DELEGATED DECISION

Item No.	Report of the Head of Planning, Transportation and Regeneration
Address	LAND TO THE REAR OF 45 SEATON GARDENS RUISLIP
Development:	Erection of a two storey dwelling with associated access, parking and amenity space
LBH Ref Nos:	70507/APP/2021/1208
Drawing Nos:	2853-2-05 Rev. A (Land beside 1 Kingswear Road, Proposed Layout) 3248-01 3248-02 3248-SS-01 3248-03 3248-SS-02 Planning Statement dated February 2021 3248-SK1 2853-2-04 Rev. A (Land beside 1 Kingswear Road, Proposed Site Layout Street Scene) Flood Risk Assessment (dated July 2021) Joint Appeal Decisions at Land to the rear of 39 and 39a Hatherleigh Road (refs: APP/R5510/W/15/3016551 & APP/R5510/W/15/3016555)

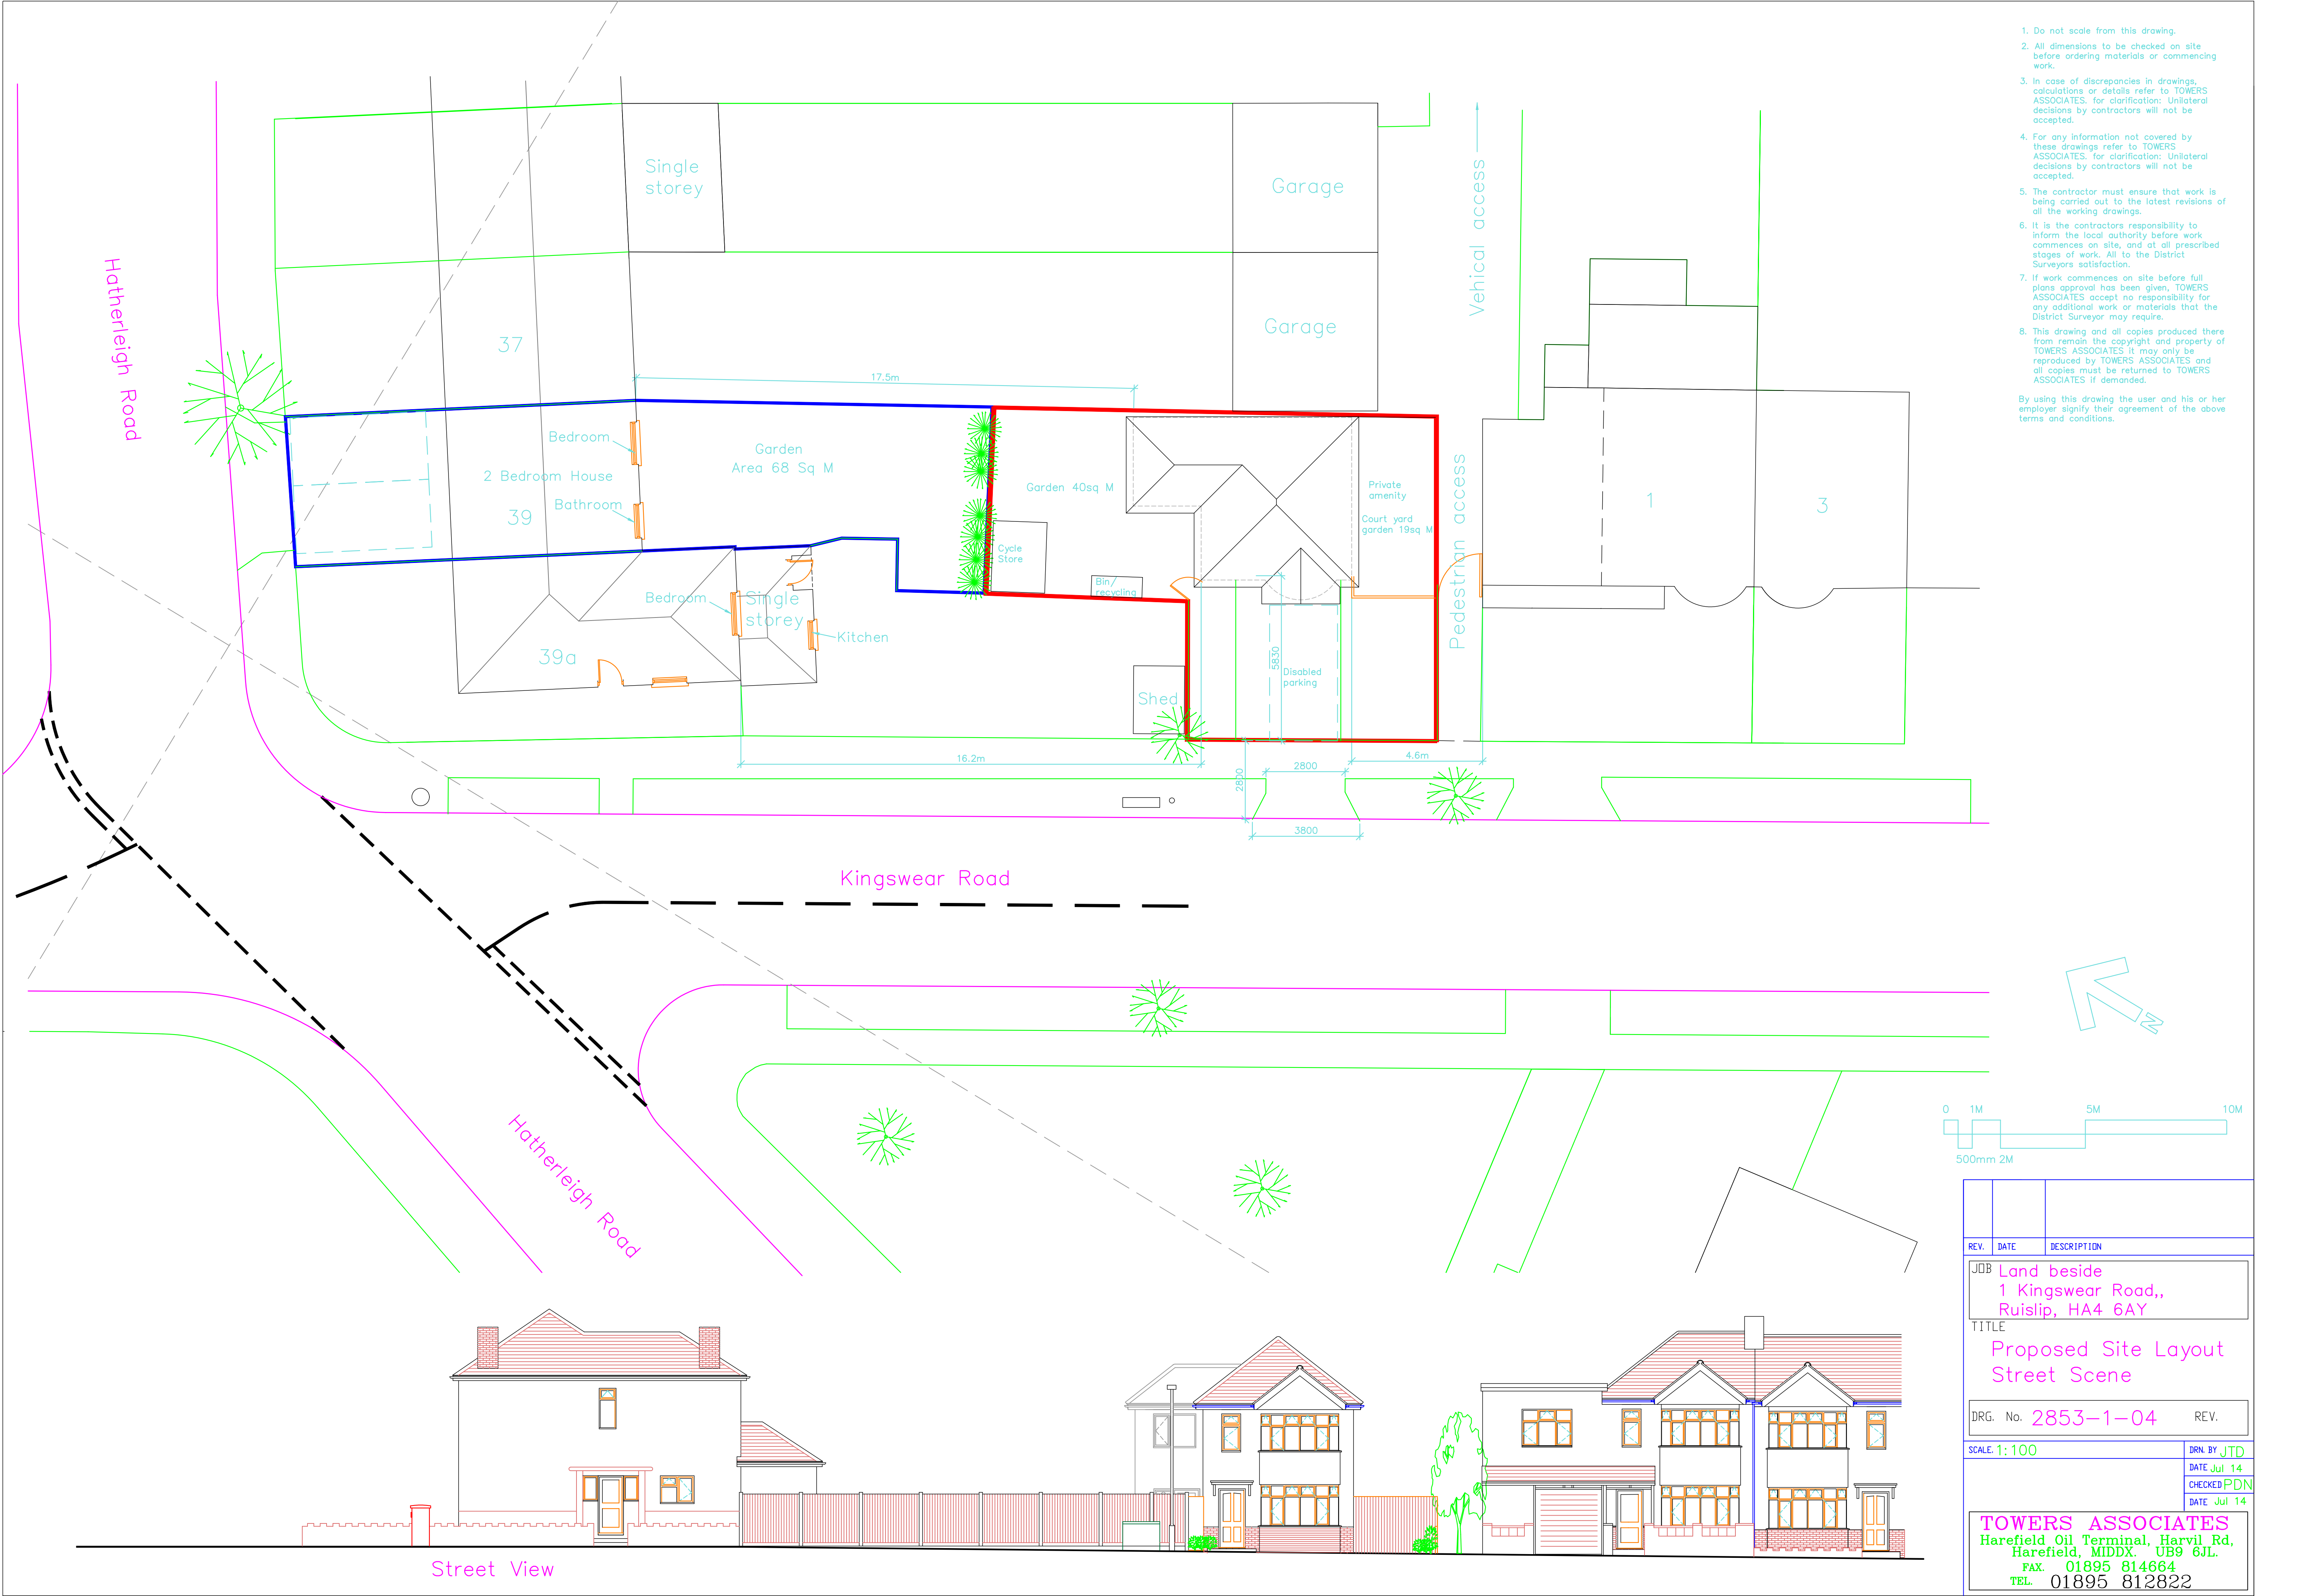
Number 47 Seaton Gardens is located to the east of the application site. Unlike neighbouring properties, numbers 45 and 47 Seaton Gardens do not contain a garage or outbuilding at the end of their proposed and existing rear gardens. The rear wall of the proposed dwelling would run along the mutual boundary shared with number 47 Seaton Gardens for a distance of 7.7 metres. Furthermore, the proposed dwelling, with a two storey height, would only be sited some 7m from the boundary of the rear garden of No.45. Due to this relationship, coupled with the scale, size and height of the proposed dwelling, it is considered that the development would have a significant enclosing effect and thus be dominant and overbearing when viewed by the users of the private amenity space at numbers 45 and 47 Seaton Gardens.

It is noted that there is an existing garage at the application site which runs along the mutual boundary shared with number 47 Seaton Gardens. However, this garage is single storey in scale and has a flat roof profile. It is therefore considered that this structure is not comparable to the scale, size and height of the proposed two-storey dwelling. As such, it is considered that the existing garage would not justify the harm identified in the previous paragraph.

The proposed dwelling would not contain any windows fitted in its rear and side (south) elevation. The ground and first floor windows fitted in the side (north) elevation would serve non-habitable rooms and would be conditioned to be obscure glazed and non-opening up to 1.8 metres. It is therefore considered that the proposal would not give rise to a material loss of privacy or overlooking for neighbouring occupiers.

The submitted site layout plan indicates that the proposed dwelling would be provided with 63 square metres. However, the footprint covered by the shed/ cycle store should not be taken into account as this area would not constitute as usable private amenity space. When the shed/ cycle store space is discounted, the actual usable private amenity space would measure 59.25 square metres which would fall below the minimum requirement. If planning permission were to be granted, a condition would be secured requiring for shed/cycle store to be reduced to ensure that the minimum 60 square metres of usable private amenity space is achieved.
